**Consultation Response from KC,
Highways Development Management**

2026/91475 adj, Huddersfield Open Market, Brook Street, Huddersfield, HD1 1RY

Discharge of details reserved by conditions 6 (bin storage), 7 (crime) on previous permission 2025/93197 for erection of free standing single storey structure to be used as temporary indoor market (sui generis) with associated facilities, office cabins, waste compound, parking spaces and works (within a Conservation Area)

Date Responded: 04/06/2026

Waste Storage Enlarged Plan

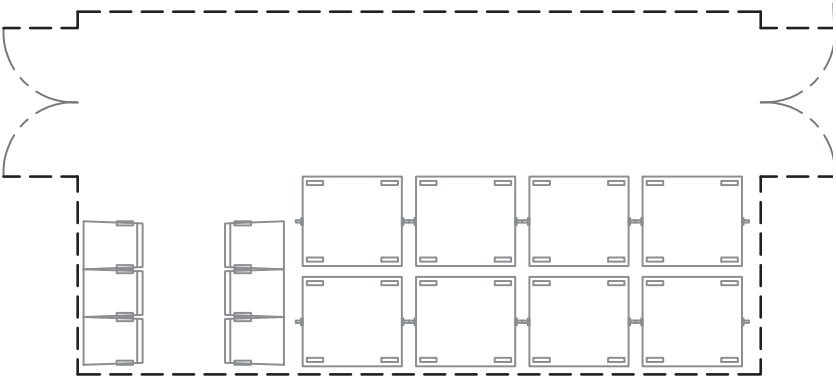
(i) The location of the bin store is away from the adopted highway and therefore the bins will not cause an obstruction to vehicles, and this is acceptable.

(ii) The waste collection presentation point is located to the front of the bin storage compound meaning that drag distances are kept to a minimum and access to the collection point can be made by a refuse collection vehicle (swept path analysis was provided as part of application 25/93197 in drawing No C121 P01) and this would be acceptable, however the collection point requires a refuse vehicle to reverse through a public car park and as servicing is limited to 9am to 4pm, this would need to be done while the car park is attracting a peak demand and this would be a highway safety concern.

Waste Management Proposal Diagram

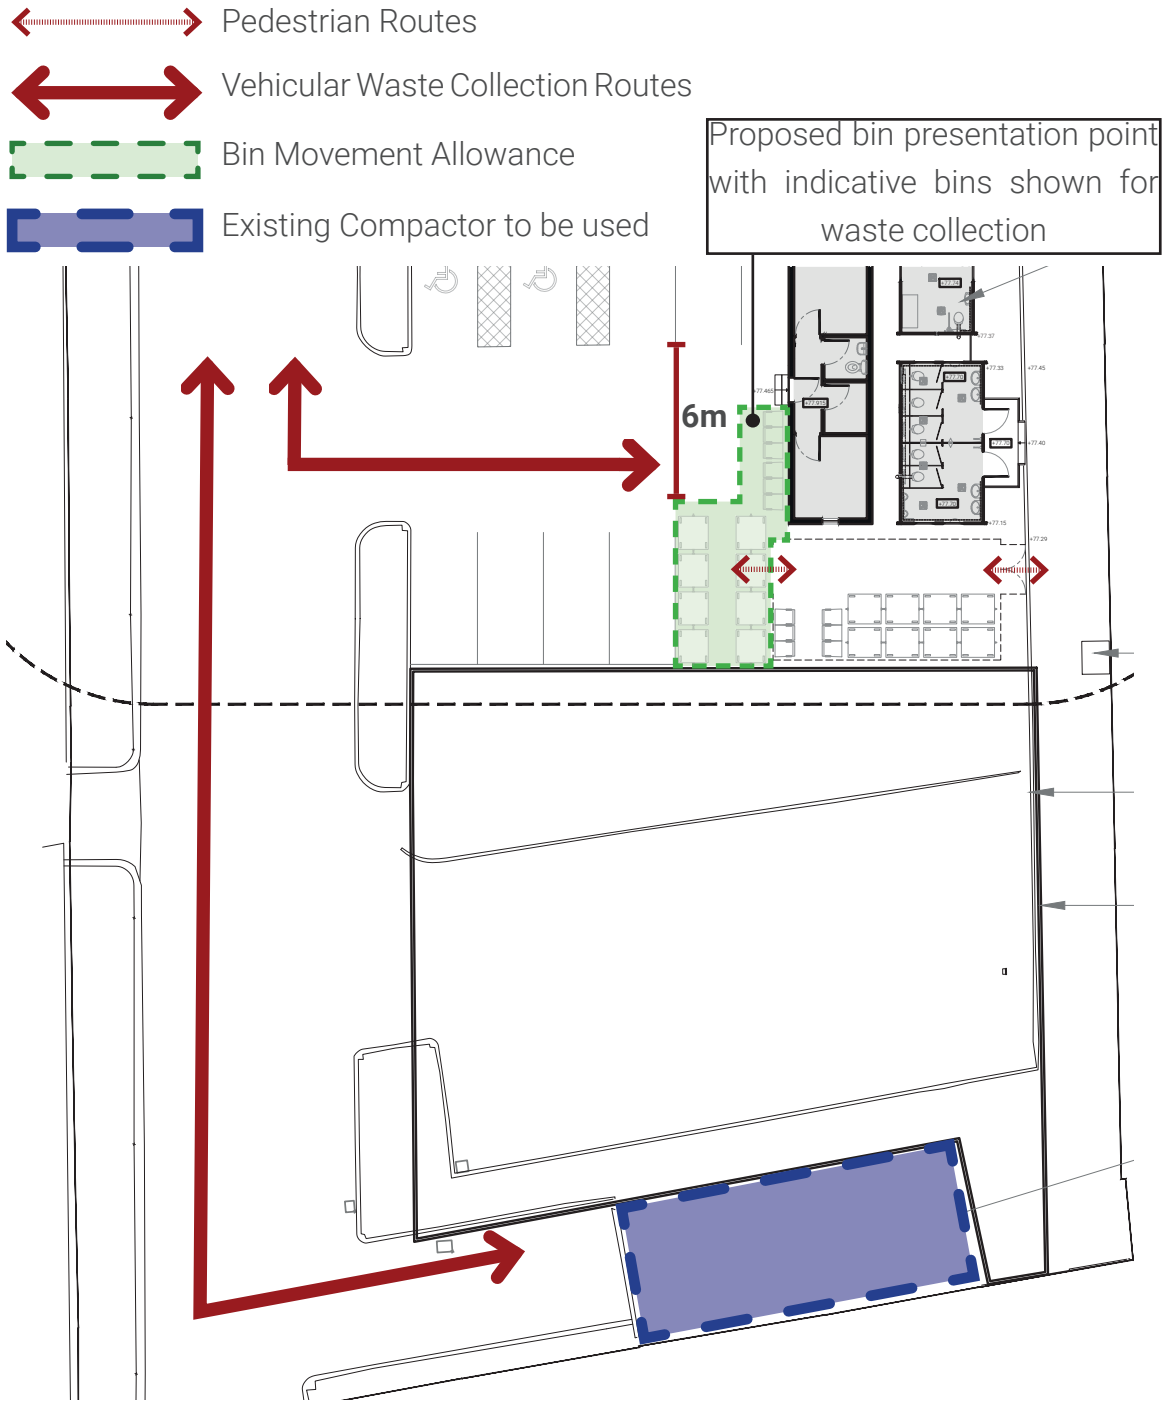
We would like to see the collection point relocated away from the car park and would suggest that it is moved to adjacent to the compactor to the south of the site. This would increase the drag distance that the Market Management team would have to move the bins on collection day, however as there is no reason for vehicles or pedestrians to be within the area to the front of the compactor, HDM consider this a safer location for temporary collection.

With this we cannot currently support the discharge of condition 6 on highway safety grounds, however if the collection point can be relocated to remove the requirement for a refuse wagon to need to reverse through a public car park, we may be able to re-assess the application with a more positive outcome.
